RE: **Albert Townhomes , 324 Vassar Drive NE**
Request For Permanent Certification of Occupancy For Entire Site
Engineer's Stamp Date 5-13-2010 (K16/D077)
Certification Stamp Date 3-21-2014

**Re: Albert Townhomes, Grading and Drainage Plan
Engineer's Stamp date 5-13-10 (K16/D077)**

Re: Albert Townhomes, Grading and Drainage Plan
Engineer's Stamp date 5-7-10 (K16/D077)

324 VASSAR DRIVE SE  
ALBERT TOWNHOMES  
Grading & Drainage  
Plan

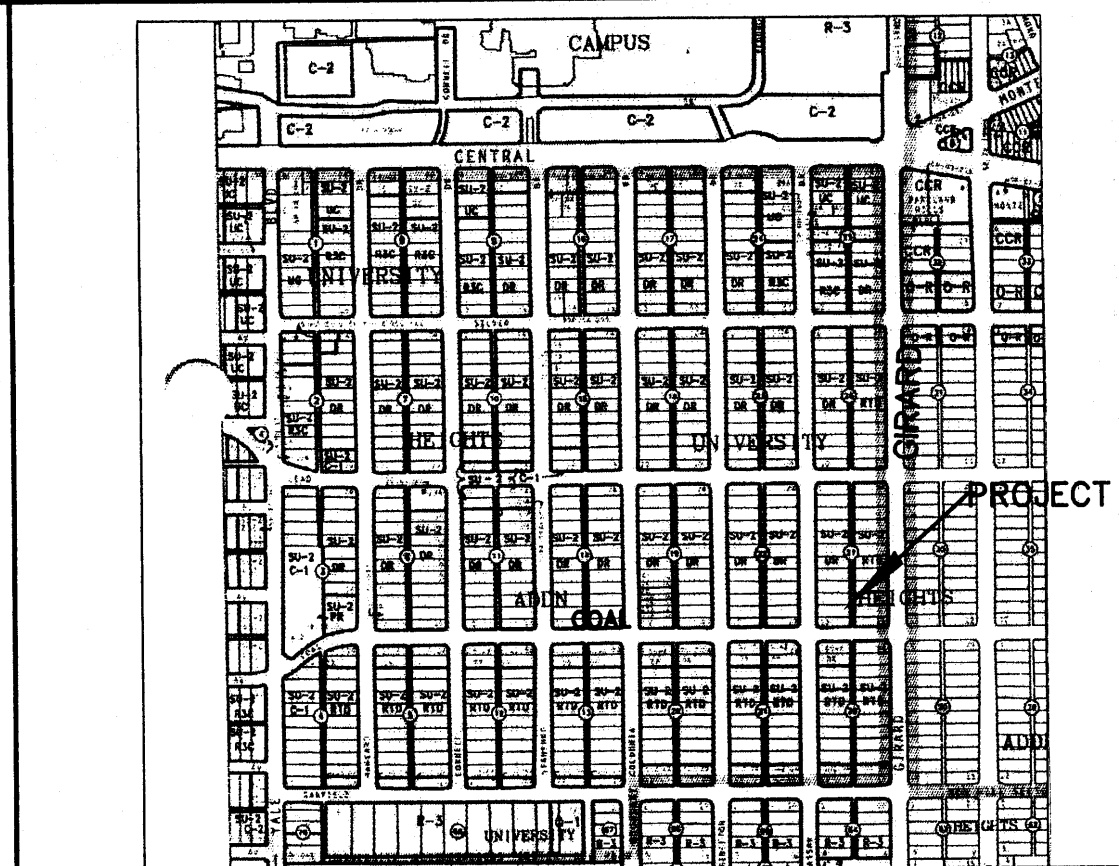
Based upon the information provided in your submittal received 5-7-10, the above referenced plan cannot be approved for Building Permit until the following comments are addressed:

- If the townhouses are two stories the roofs that drain north are to have gutters and downspouts.
- It is not clear how/if the landscape area north of the buildings will drain. Grades must be provided so that this area does not drain to the north.
- Provide a spot elevation at the turn block in the patio walls.
